Item No. **Report of the Head of Development Management and Building Control**

Address: THE PLOUGH SIPSON ROAD SIPSON

Development: Replacement of existing 4 external elevations white paint to new Tuscan Olive paint.

LBH Ref Nos: 1140/APP/2025/1199

PROPOSED FRONT & REAR ELEVATIONS
DWGS REF. ZDD UB7 0HW REV A: 404

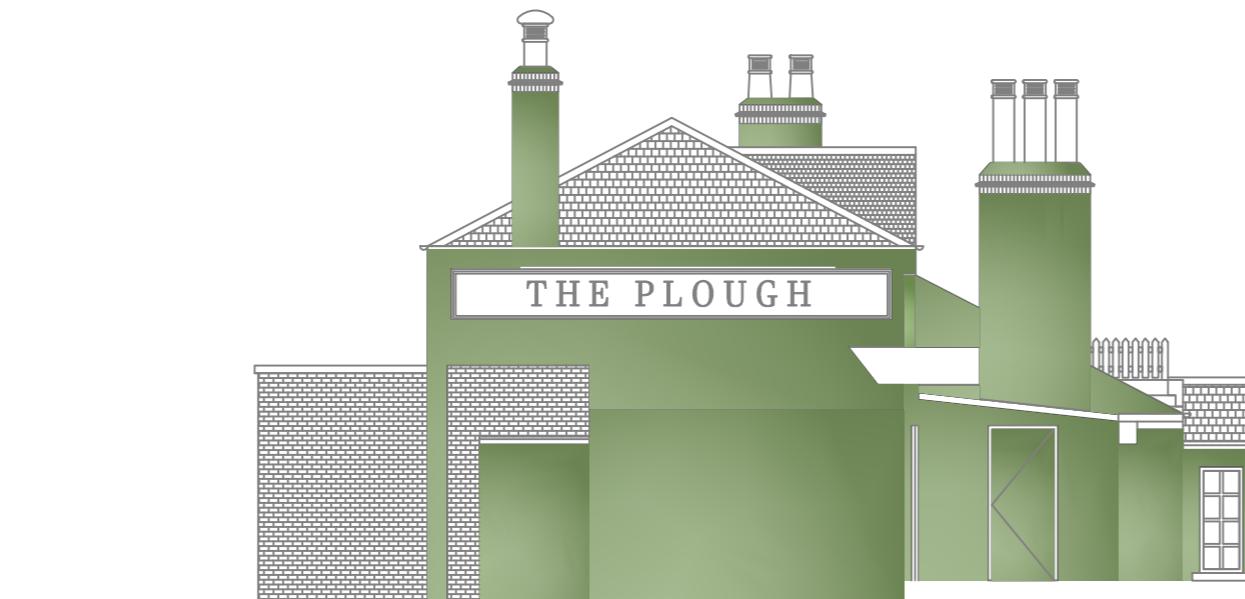
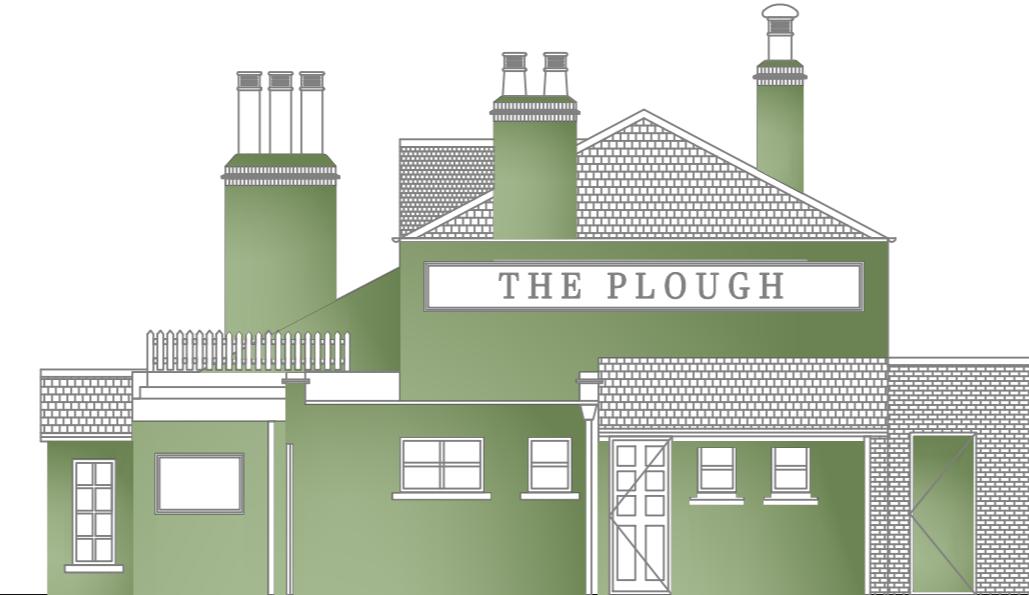
We are pleased to see that the proposals include painting the small brick extensions to match the colour of the rest of the building. It is not clear from the documents whether the wall and fence along the frontage are included in the repainting. If not, they should be as a dirty, white-painted wall and picket fence will detract from the new look, especially as the proposal is to change the building colour from the traditional white to olive green.

This is a 19th century public house which makes a contribution to the character of the area. In general we would not object to the proposals. However it would be recommended that minor changes be made to better reflect the character of the building. The two single storey brick buildings to the access road should be left as unpainted brick. In addition it may be useful to consider retaining the chimneys above roof level in their existing colour. This would help preserve the character of the building whilst allowing the change in branding. It may also be useful to paint the security gate/ fence to tie in with the general refurbishment.

The Comments made by Heathrow Villages Conservation Area Advisory Panel are noted. The proposed drawings show the boundary wall and fence will be painted Tuscan Green to match the proposed refurbishment. During the process of the application revised drawings have been sought to keep the brick extensions unpainted to better reflect the character of the building as per the Conservation Officers comments below.

Revised drawings have been sought and received to keep the brick buildings and chimney stacks unpainted. Requests were made to paint the security gates/fences, however, as they are galvanised steel, this would not be possible.
